CITY OF ALBUQUERQUE

May 7, 2018

**RE: L&C Transport Office and Shop
108 94th St NW
Conceptual Grading and Drainage Plan
Engineer's Stamp Date 4/25/18
Hydrology File: K09D043**

GRADING AND DRAINAGE PLAN

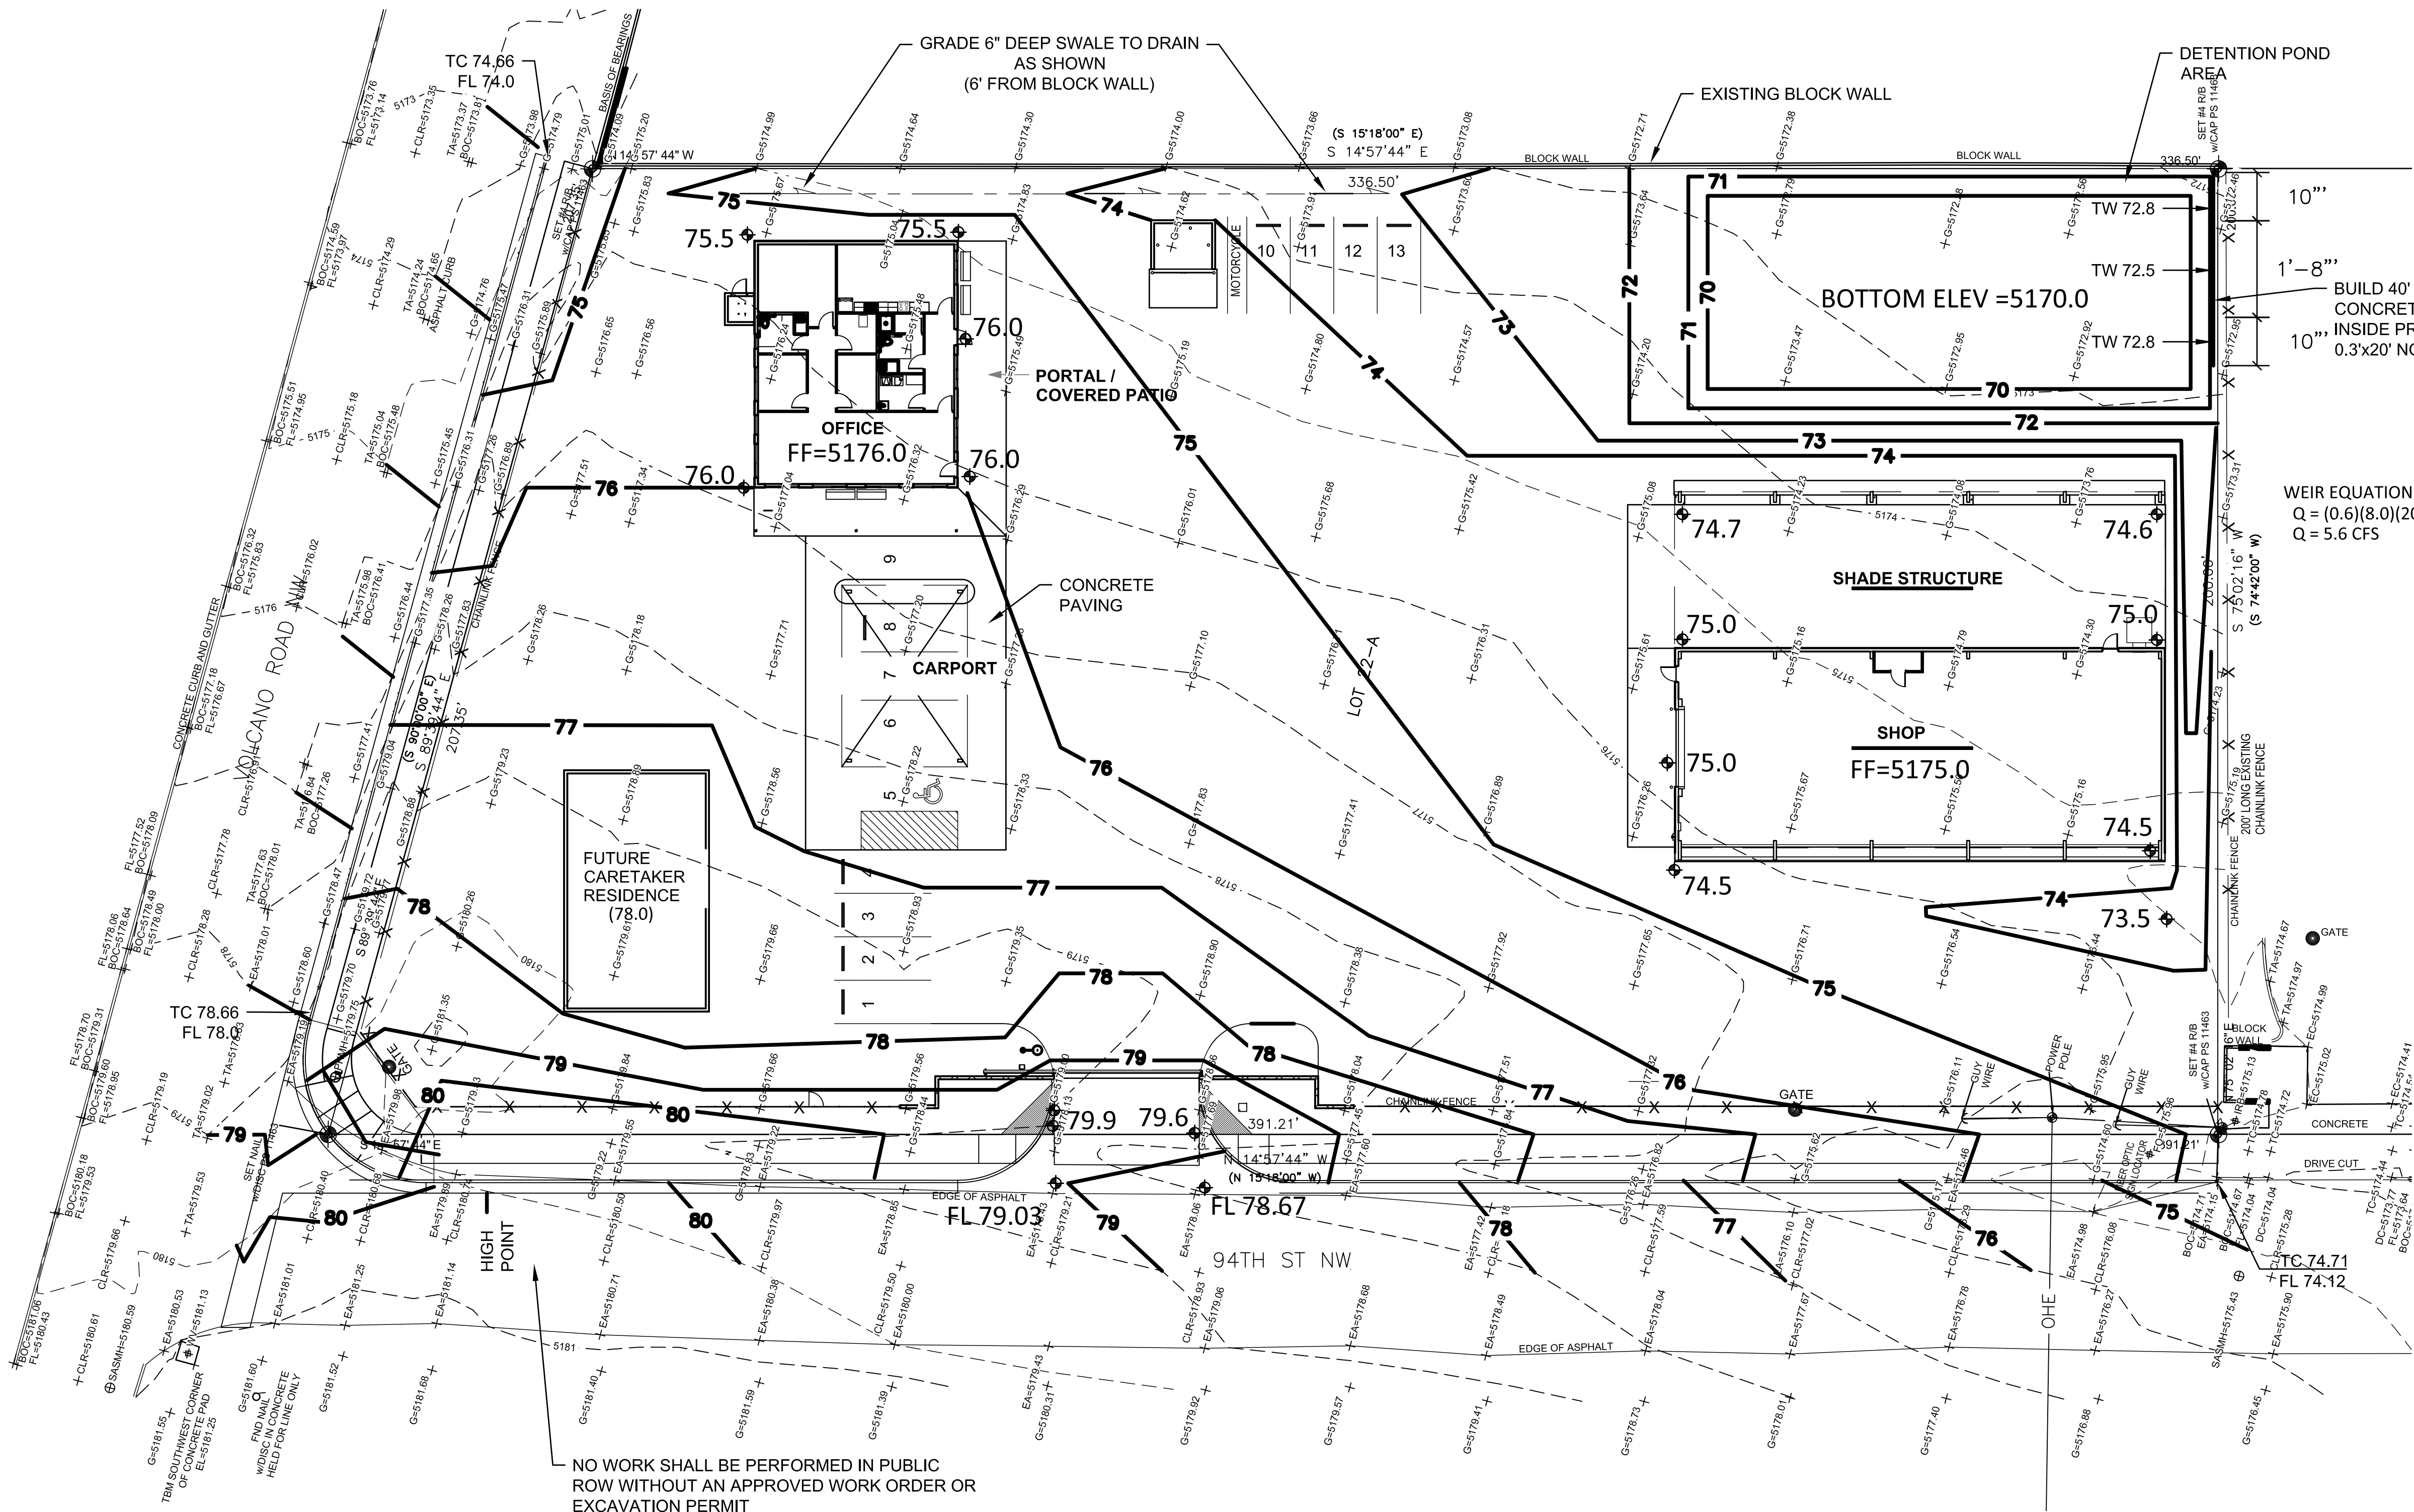
1. Provide valley gutter across 94th St at the intersection of 94th and Volcano.
2. On the retention pond, provide a non-erosive emergency overflow, sized for the 100-yr peak inflow.
3. Provide a 0.87' waterblock at the entrance to your site.
4. Add note on the plan that "No work shall be performed in the public ROW without an approved Work Order or Excavation Permit."

5. Provide additional detail along the eastern property line and existing block wall. It appears that a swale or berm will be needed here to keep flows away from the block wall and conveyed into the retention pond.
6. Provide section views though the pond and adjoining property lines. If a berm is required, it will need to comply with Ch. 22, section 3, part F.
7. A Drainage Covenant (No Public Easement) is required for the stormwater retention pond. The original notarized form, exhibit A (legible on 8.5x11 paper), and recording fee (\$25, payable to City of Albuquerque) must be turned into DRC (4th, Plaza del Sol) for

8. Remove all "Conceptual" markings.
9. This project requires an ESC Plan, submitted to the Stormwater Quality Engineer (Curtis Cherne PE, ccherne@cabq.gov or 924-3420).
10. Additional comments may be provided at Building Permit, based on the outcome of the above remarks and level of detail shown on plans.
